REPORT UPDATE

Application No: M/47/21/HH

Recommendation Report for Planning Permission for Works or Extension to a Dwelling

PROPOSAL: Removal of existing roof structure, new first floor accommodation and pitched roof above and replacement rear two storey extension and new front porch extension.

PROPOSED ELEVATIONS

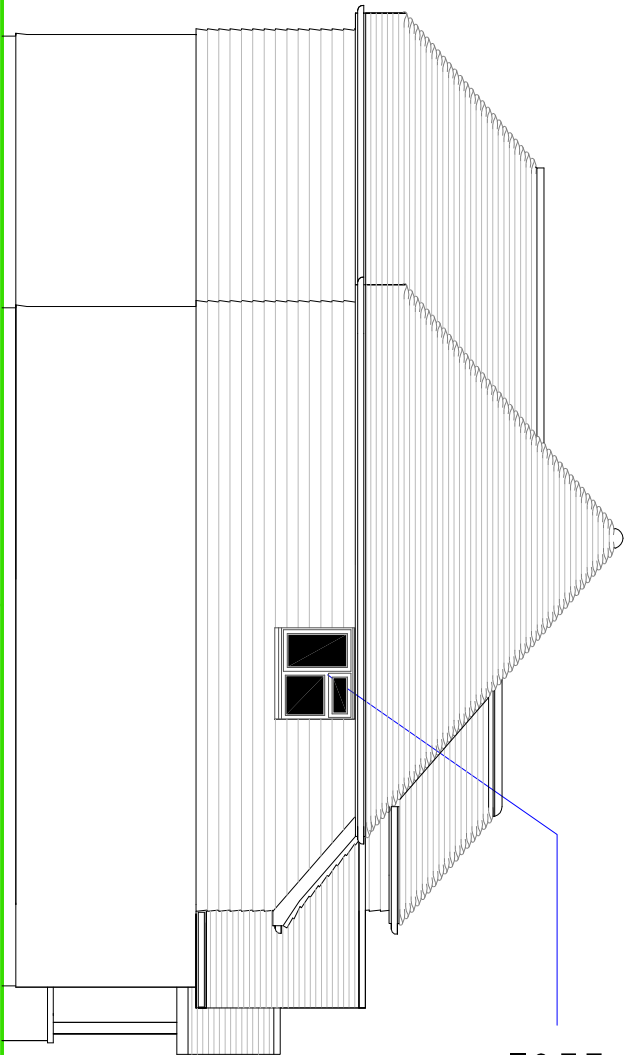
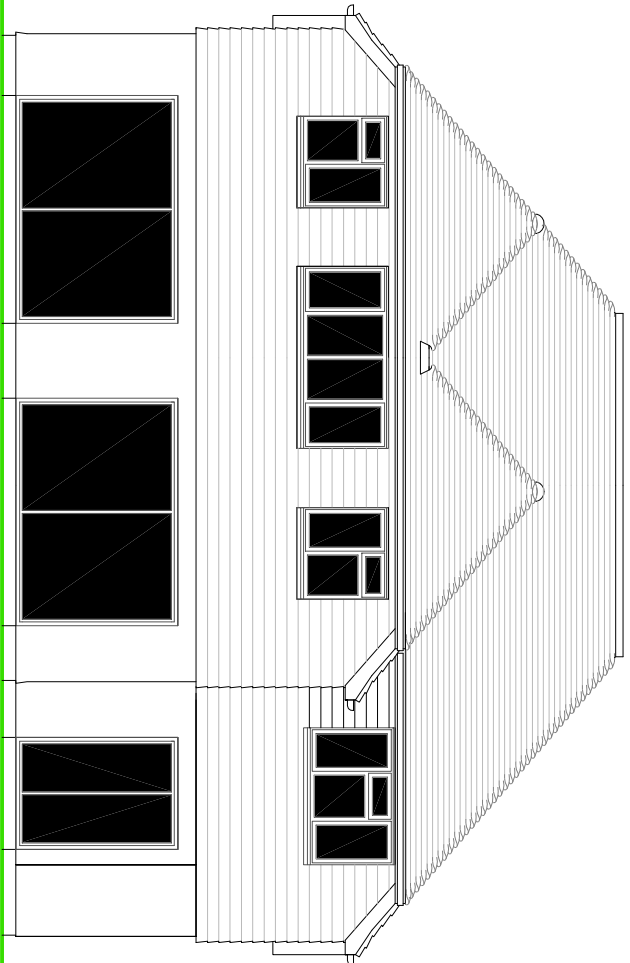
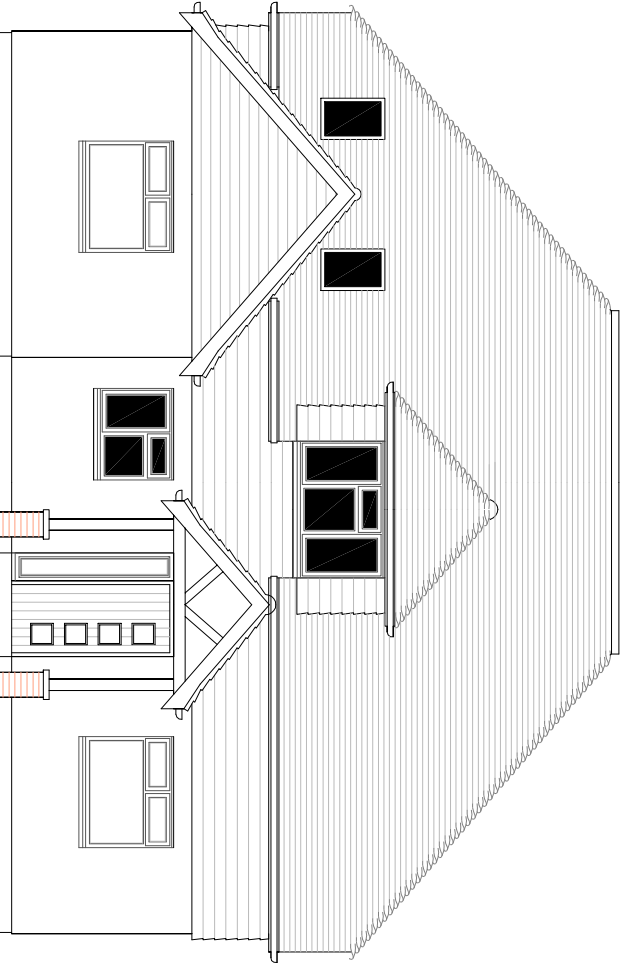
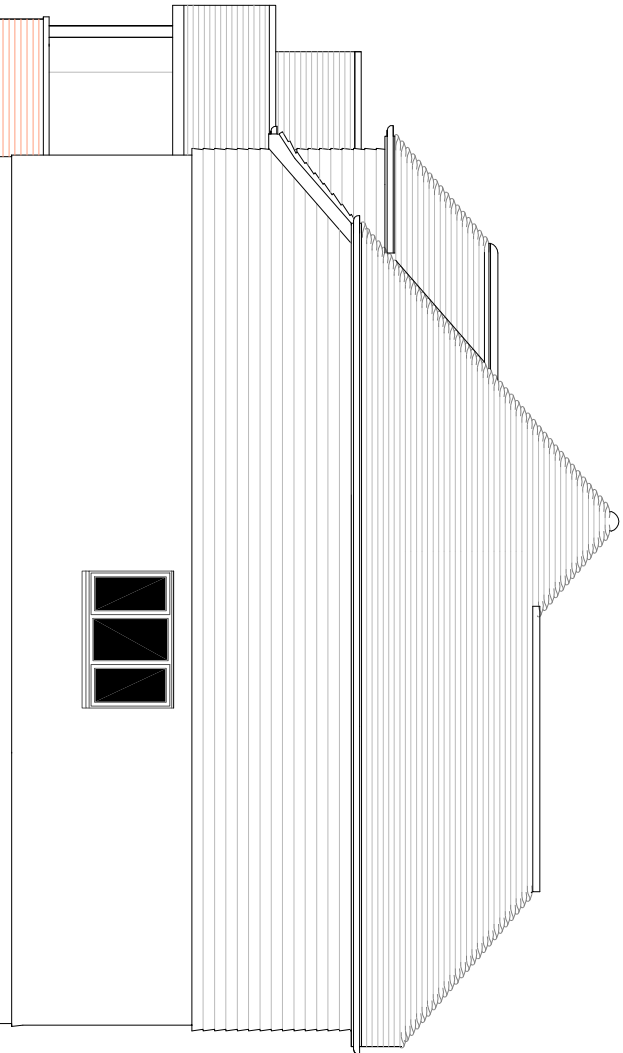
To the rear alterations are more significant. On the southern elevation a two-storey extension is proposed. Its scale and visual dominance compared with the existing dwelling is contrary to D DM4(b). However, attempts have been made to soften the dominance of the roof with the addition of catlides to east and west elevations. When considering its scale and massing against the footprint increase the extension footprint is quite minimal and does not protrude further to the south than building lines extending from the rear elevations of either adjoining neighbours. Its height, although slightly higher is comparable to neighbouring properties within Tudor Close. The extension meets the 45-degree rule. A garden depth of 14.6m is retained in line with guidance. The Arun Design Guide states rear extensions provide applicants an opportunity for more creative and architectural freedom as they are visually less obtrusive than anything seen from the public realm. Although the proposal is visually dominant, it sits in a good sized plot and is acceptable as it meets with all other the criteria above.

The proposal has allowed for new first floor fenestration to south and north elevations, along with a new ground floor window to the east elevation. The window to the east elevation would be allowable under permitted development rights. The fenestration to the north elevation would only achieve views over the public realm and are acceptable. The objections to the rear fenestration in terms of loss of privacy to neighbours are noted. There are large separation distances between rear facing elevations of 22 and the properties fronting Middleton Road. A similar perspective of facing windows exists between the backs of 21 Tudor Close and properties fronting Middleton Road. The new windows will lead to a perceived, rather than an actual loss of privacy, and are considered acceptable. A condition relating to obscure glazing to any of these windows is considered unnecessary.
